CITY OF ALBUQUERQUE

**Re: Lot 12, Sauvignon Subdivision Grading and Drainage Plan
Engineer's Stamp date 04-30-12 (E-22/D007F7)**

May 7, 2012

ENGINEER'S SEAL	LOT 12 THE SAUVIGNON SUBDIVISION	DRAWN BY WCUJ
	GRADING AND DRAINAGE PLAN	DATE 4-26-12
	 <i>Rio Grande Engineering</i> 1606 CENTRAL AVENUE SE SUITE 201 ALBUQUERQUE, NM 87108 (505) 872-0899	21212-LAYOUT-4-26-12
DAVID SOULE P.E. #14522		SHEET #  HYDROLOGIST # SECTION 21212

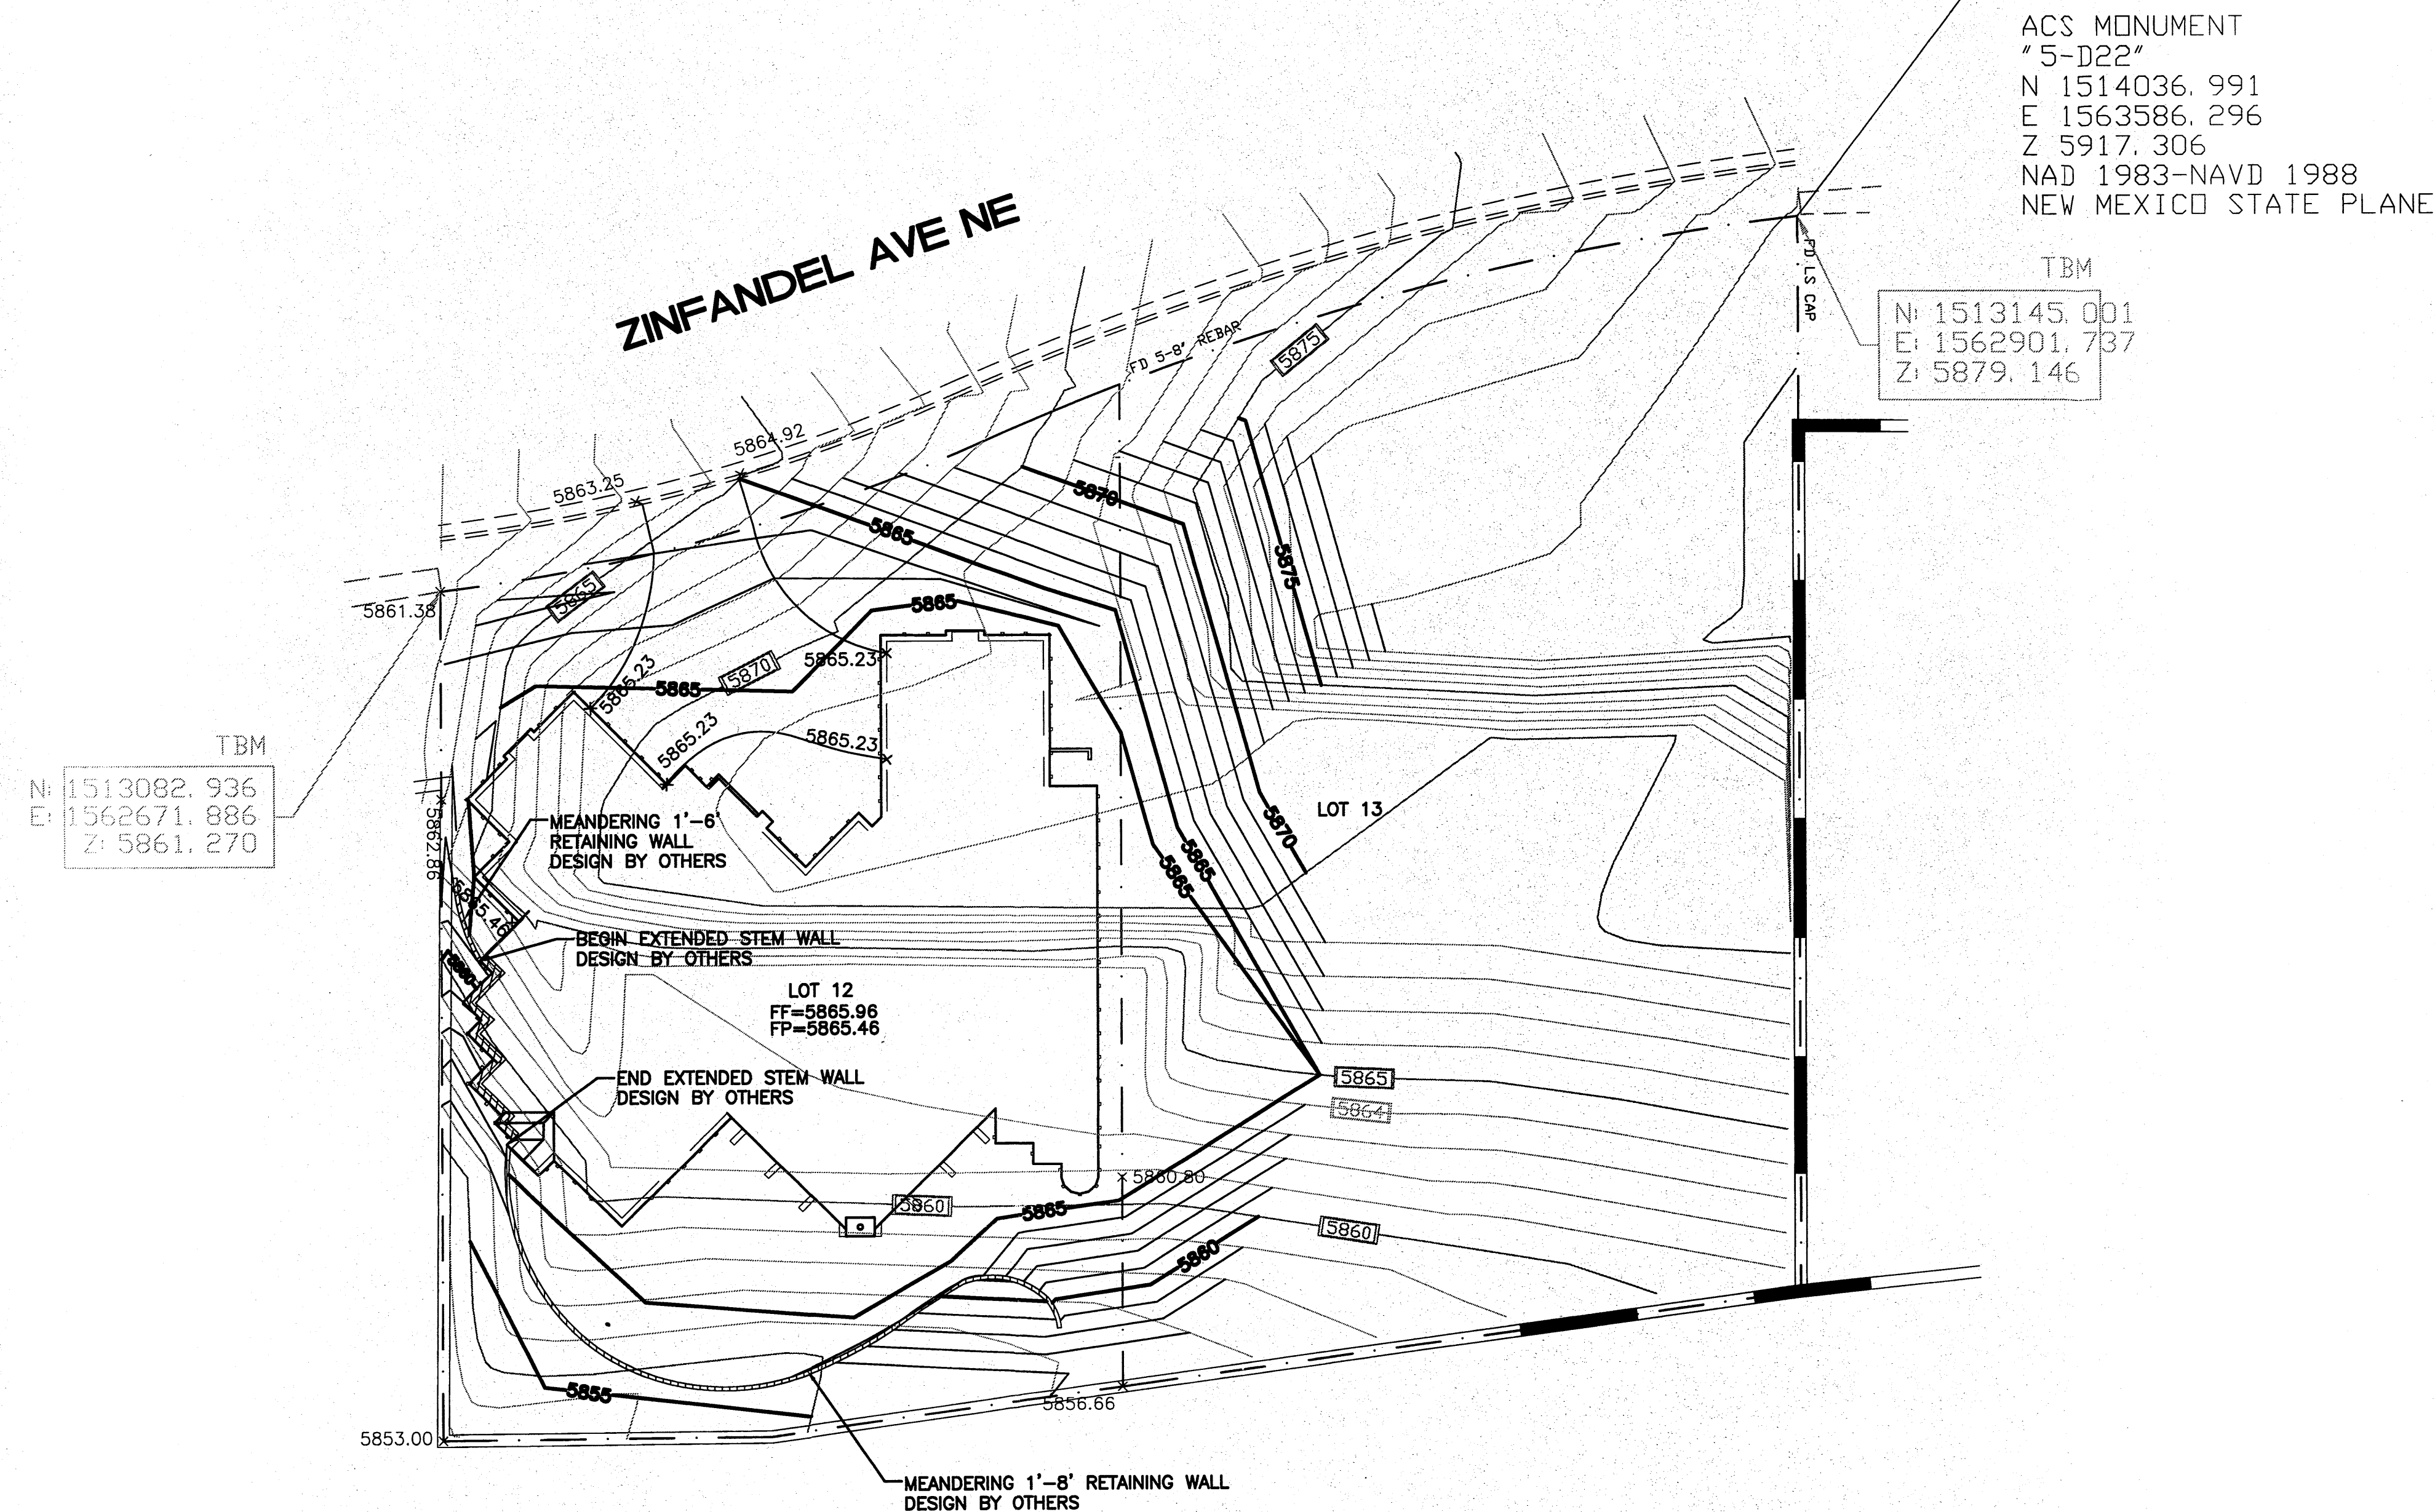
- Please provide a copy of the referenced master drainage plan for this lot indicating the allowable free discharge rate.
- In order for grading to be performed on the adjacent lot (Lot 13) a signed document must be submitted with the plan stating that the pad on Lot 13 will be impacted due to this construction activity. This document must be approved and signed by the adjacent property owner.
- Hydraulic calculations might be required based on information contained within the master drainage plan.

- Please provide a copy of the referenced master drainage plan for this lot indicating the allowable free discharge rate.
- In order for grading to be performed on the adjacent lot (Lot 13) a signed document must be submitted with the plan stating that the pad on the adjacent lot will be impacted due to this construction activity. This document must be approved and signed by the adjacent property owner. Lot 13
- Provide hydraulic calculations for both existing and proposed grading on this lot.

Based upon the letter received dated May 9, 2012 from the owner of Lot 13 the Grading and Drainage Plan is approved for Building and Grading Permit. Please attach a copy of this approved plan to the construction sets prior to sign-off by Hydrology. Prior to Certificate of Occupancy release, Engineer Certification per the DPM checklist will be required.

This letter serves as notification that Koinonia Builders Inc. is authorized to disturb lot 13 during construction of lot 12 residence and that said lot may be used for moving soil, staging and parking during construction. In addition temporary trash bin storage may be placed on said lot.
